From: Laura Gibbons
Sent: 11 December 2018 08:50
To: Planning.Responses
Subject: RE: Planning Consultation on: WA/90/18/HH

Engineers Comments Regarding Flood Risk and Surface Water Drainage

APPLICATION WA/90/18/HH

Description of Works: Retrospective application for rear single storey extension.

sheet 2 a of 3

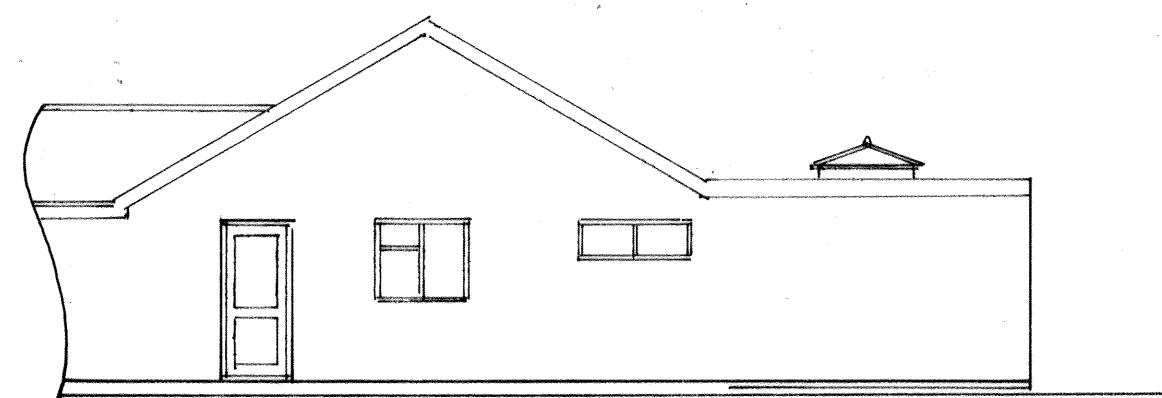
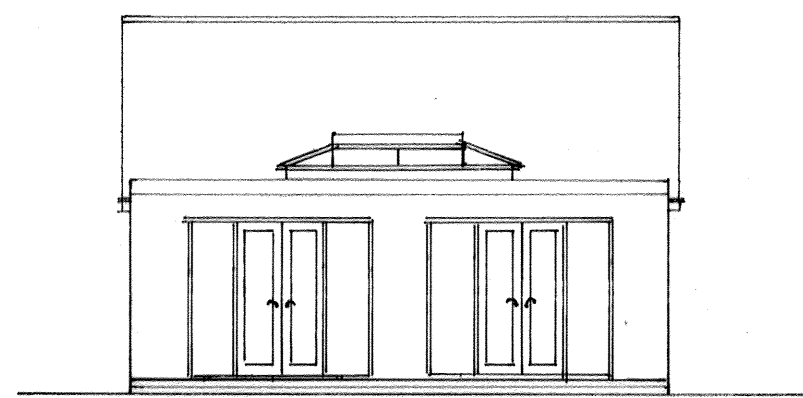
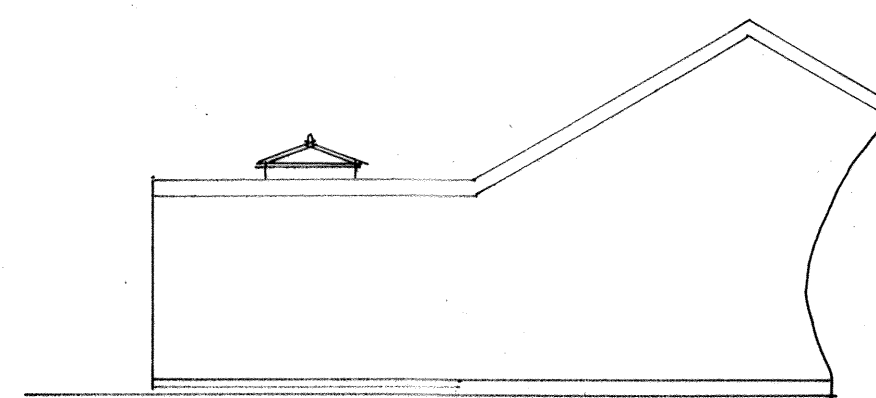
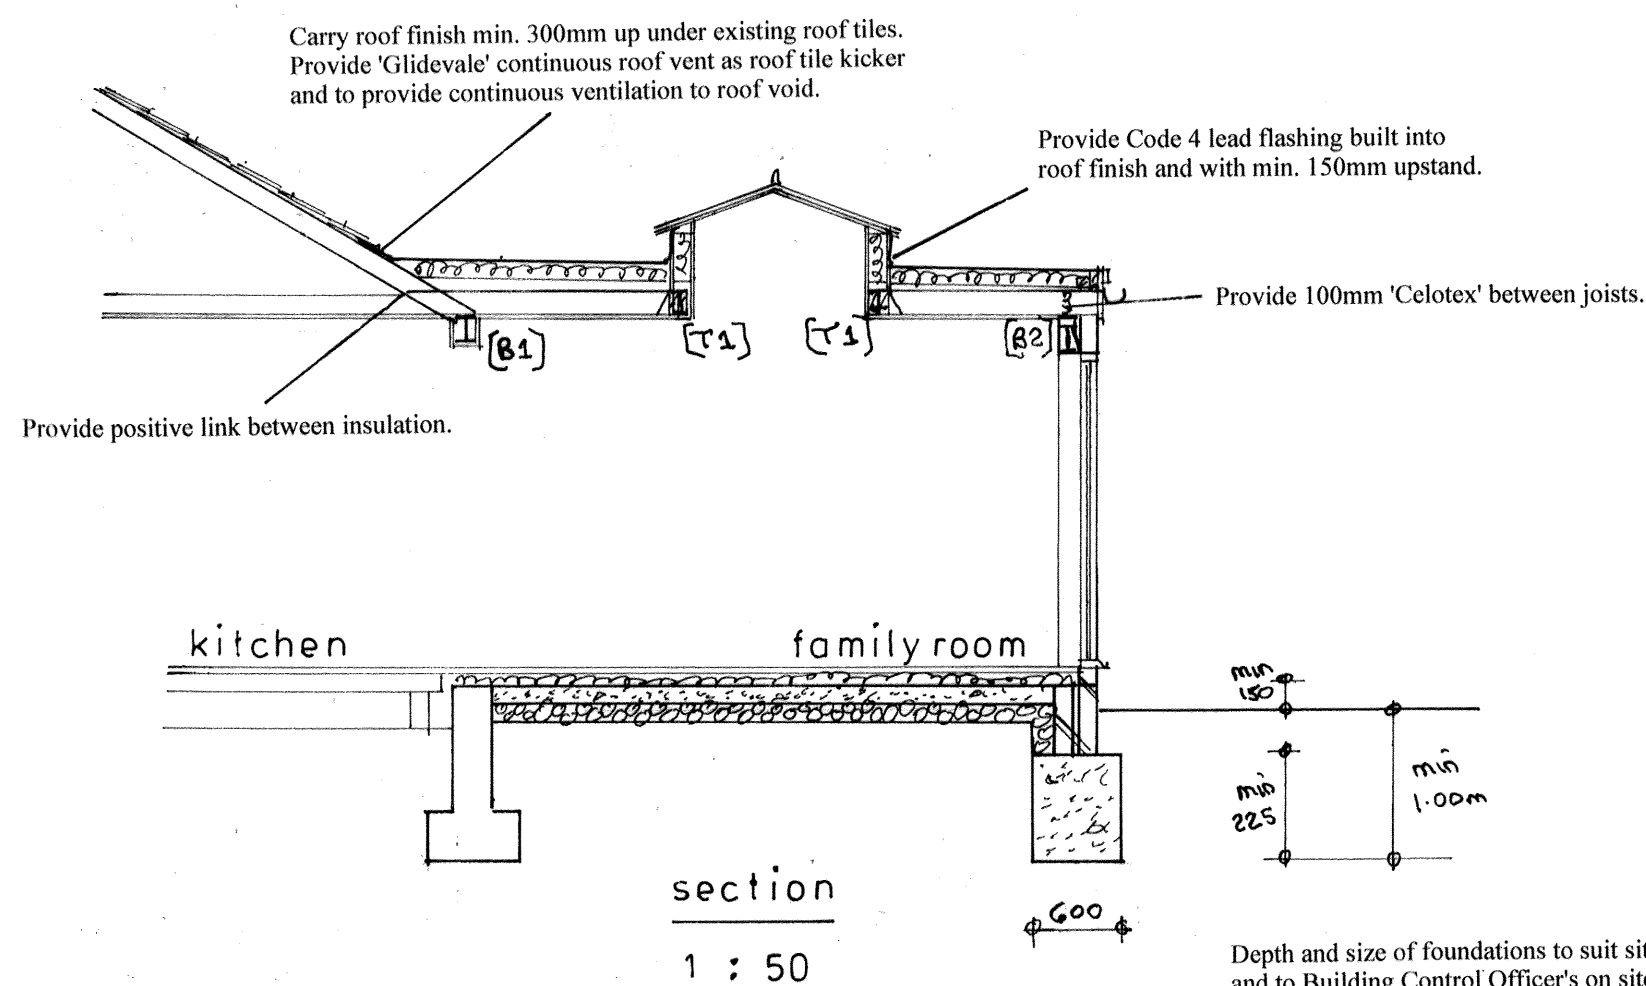
Soakaways must be investigated for surface water disposal.

Infiltration rates for soakage structures are to be based on percolation tests undertaken in the winter period and at the location and depth of the proposed structures. The percolation tests must be carried out in accordance with BRE 365, CIRIA R156 or a similar approved method and cater for the 1 in 10 year storm between the invert of the entry pipe to the soakaway, and the base of the structure. It must also have provision to ensure that there is capacity in the system to contain below ground level the 1 in 100 year event plus 40% on stored volumes, as an allowance for climate change. Adequate freeboard must be provided between the base of the soakaway structure and the highest recorded annual groundwater level identified in that location.

Any SuDS or soakaway design must include adequate groundwater monitoring data to determine the highest winter groundwater table in support of the design. The applicant is advised to discuss the extent of groundwater monitoring with the Council's Engineers. Supplementary guidance notes are also enclosed for information.
